**ADC Planning Consultation
Response from the Conservation Officer**

Application Number	K/29/15/HH
Address	The Tower Seaview Avenue Kingston BN16 1RZ
Description	Two storey extension to East, first floor extension to West & new pitched roof on existing garage (resubmission following K/20/15/HH).
Case Officer	Mr. David Easton

Drawing Name
Proposed Elevations

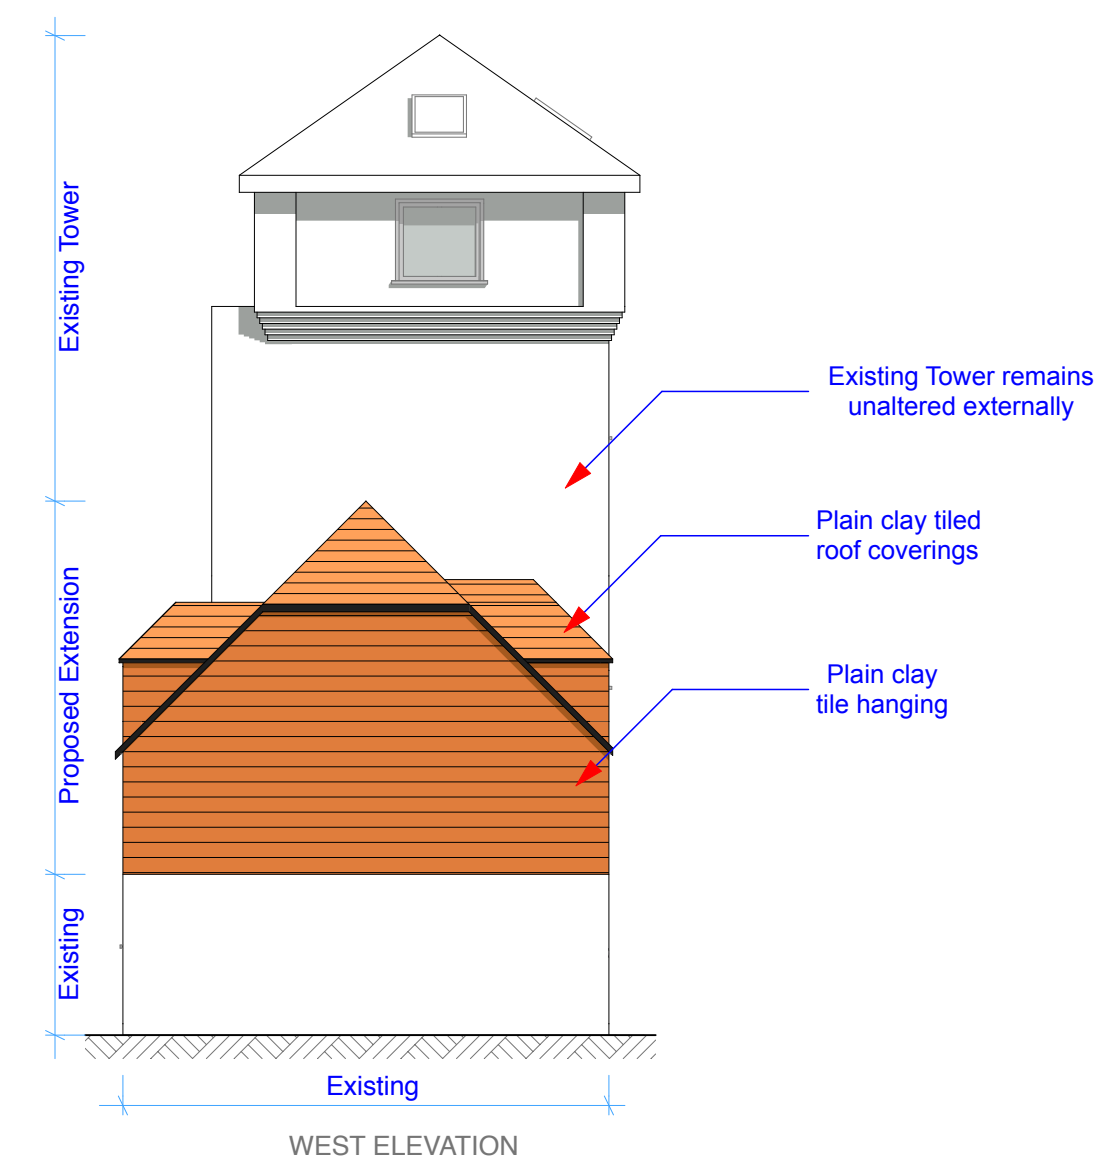
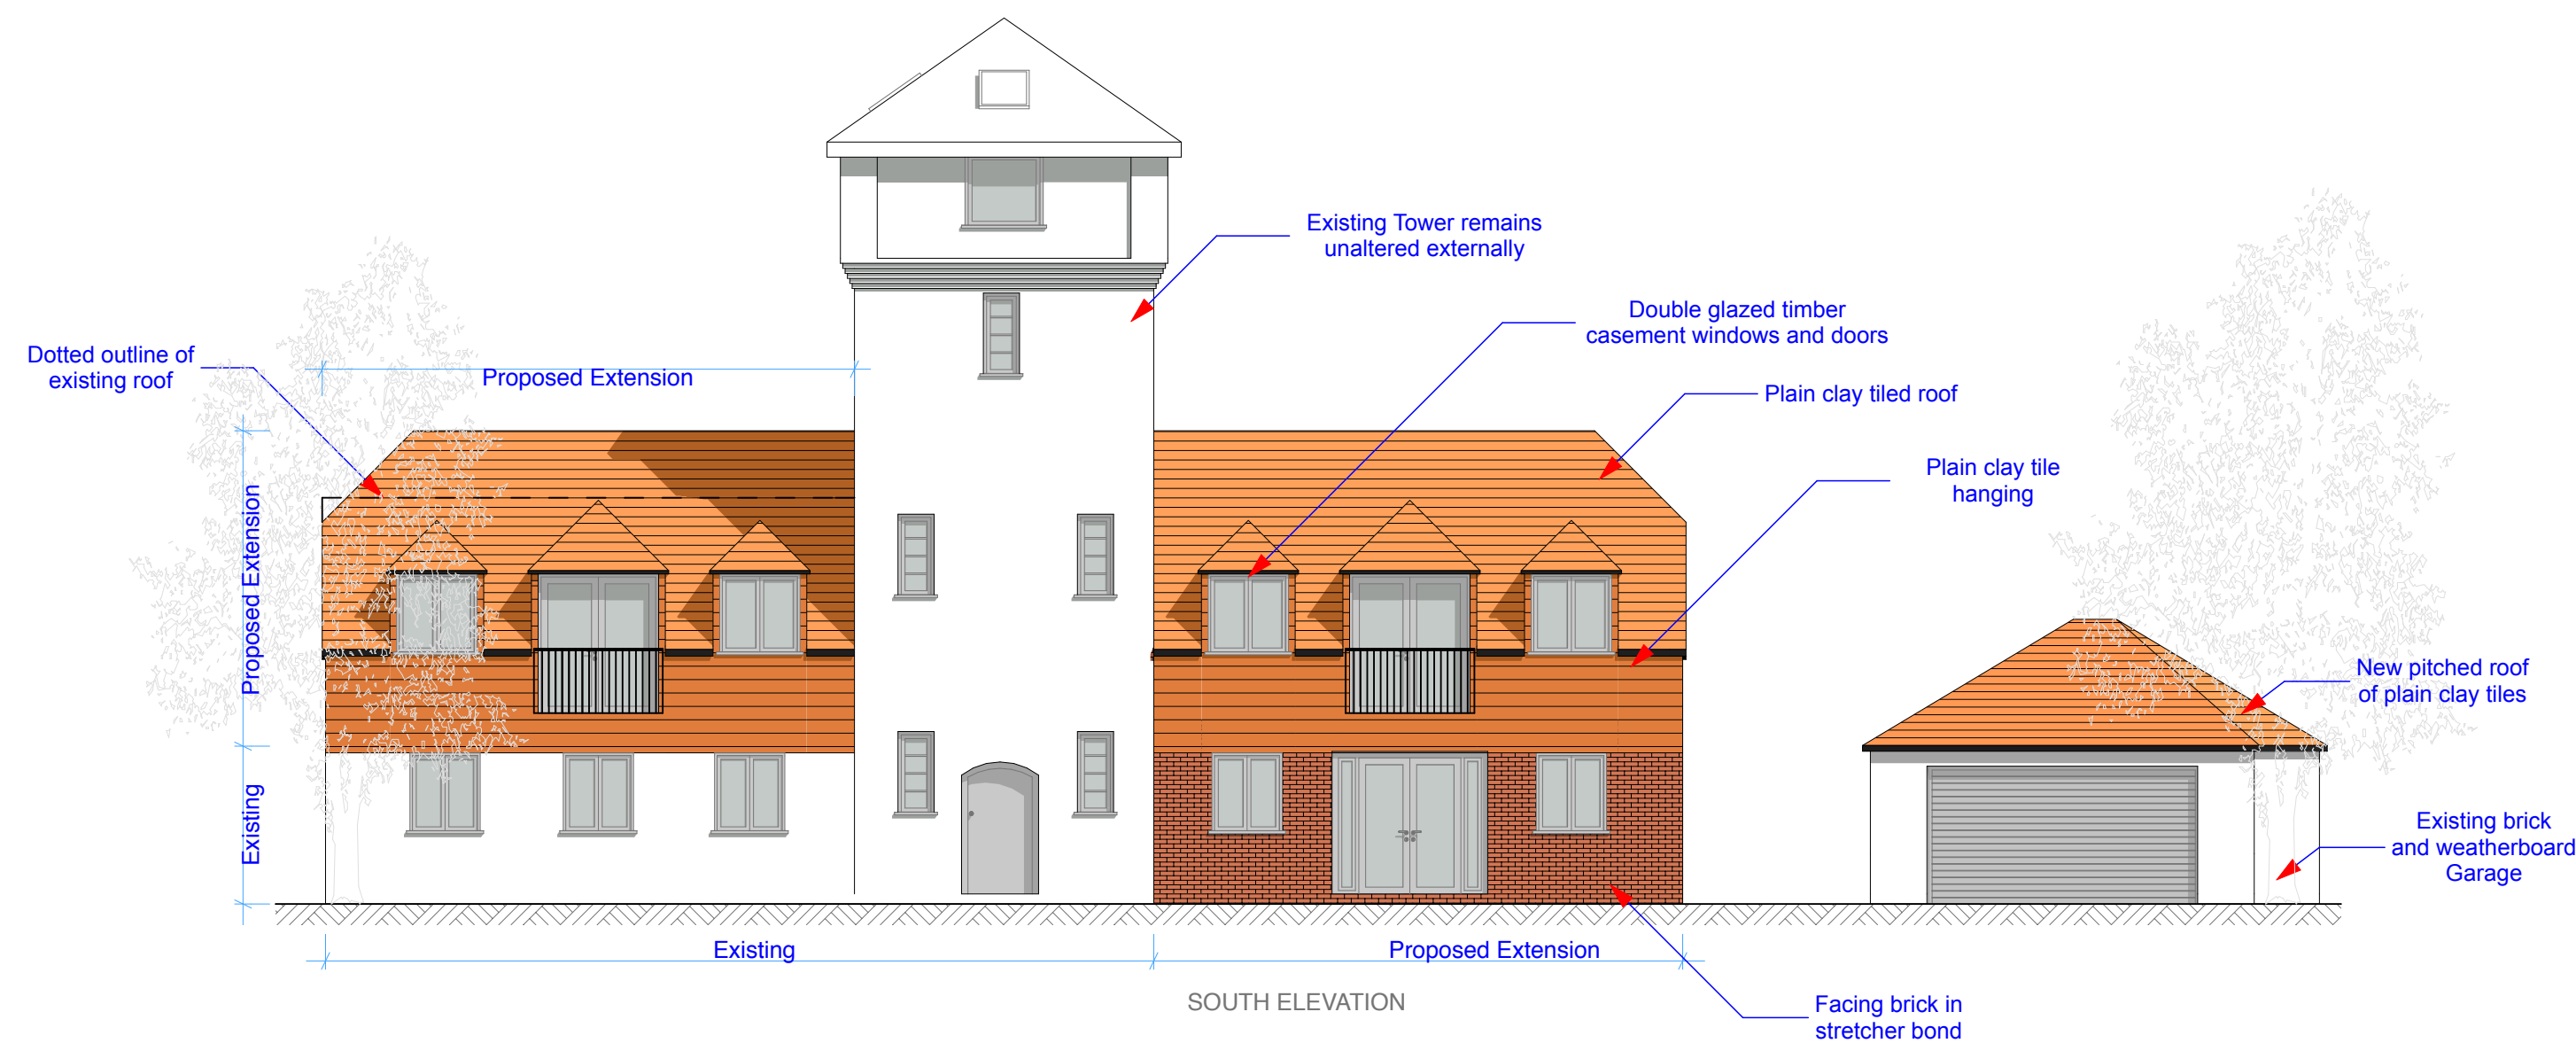
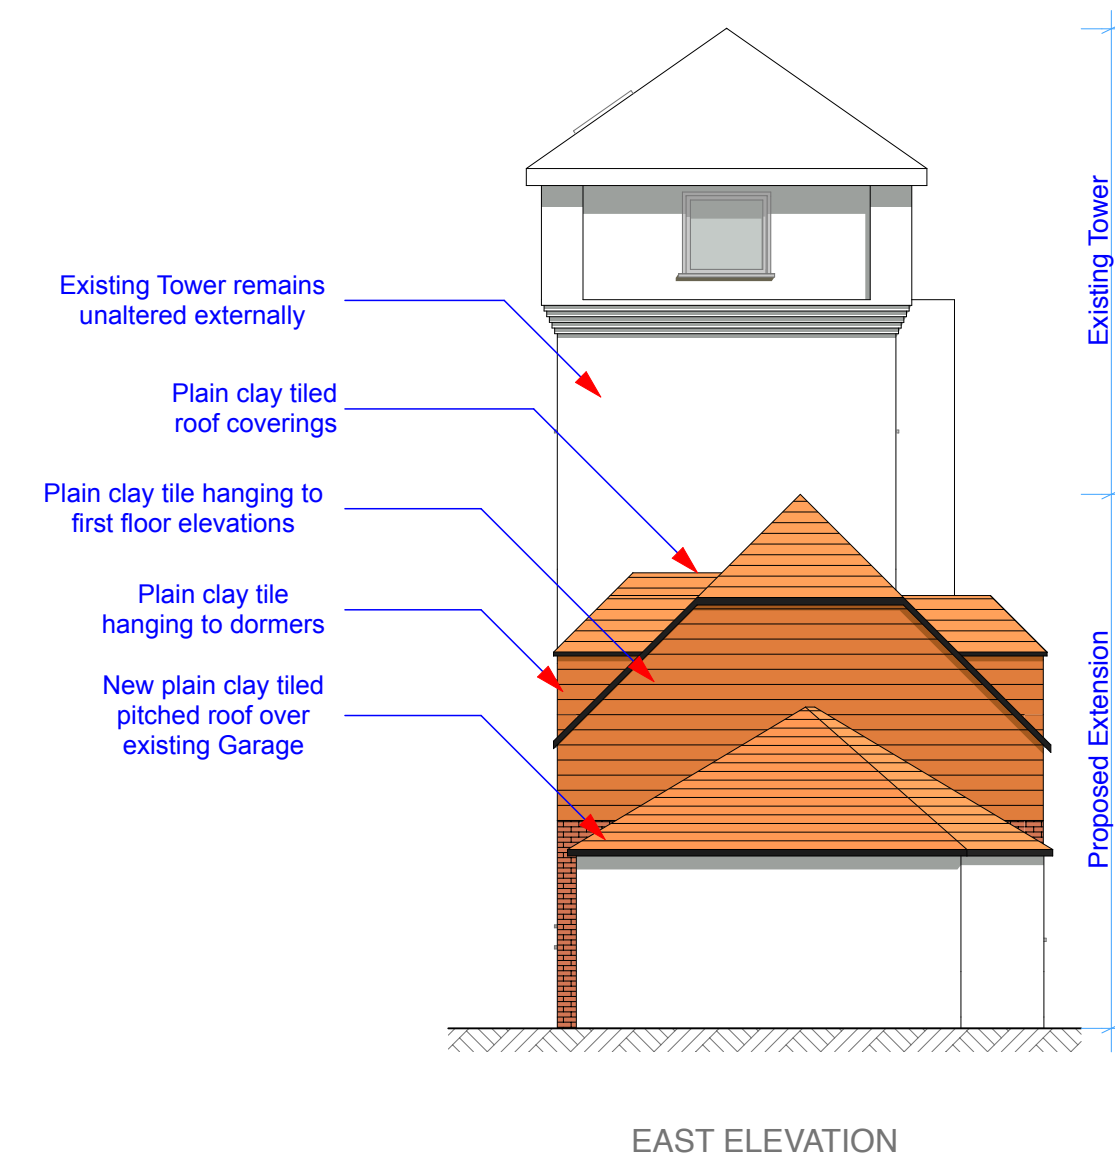
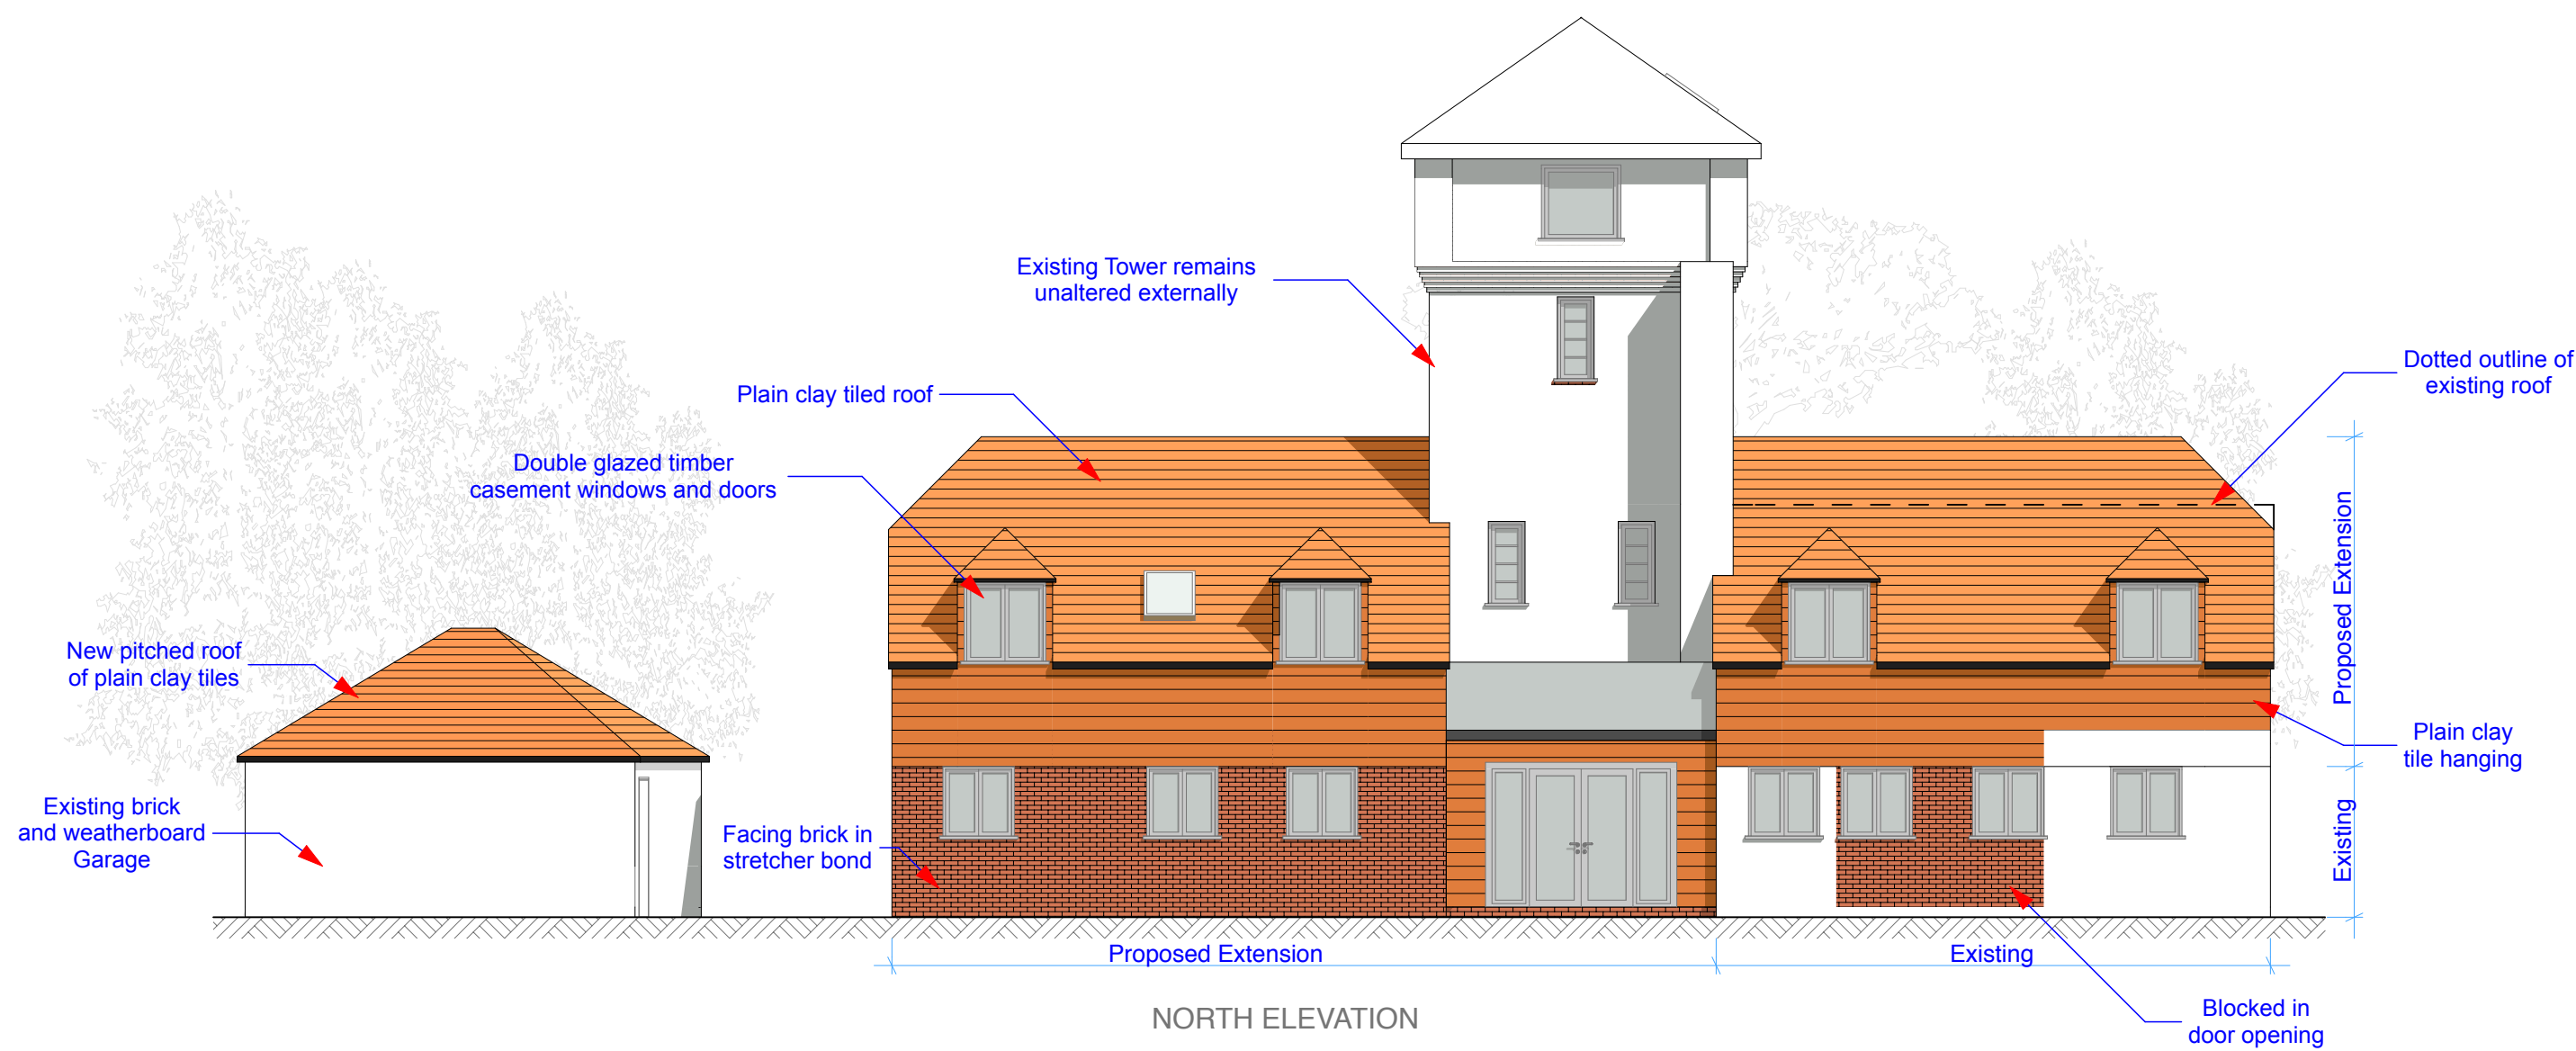
However, there is still some concern with regards to the roof structure and the impact that the dormers/windows will have upon the property. Essentially, if not careful, they have the power to become quite a dominant feature (especially the southern elevation). In addition, the use of the clay tile as part of the wall gives the impression that the roof extends down much further than it actually does. There is no easy solution to this issue, but may require some thought.

The fenestration should be designed so that it complements the property.

Details of materials, finishes and fenestration should be provided by way of condition.
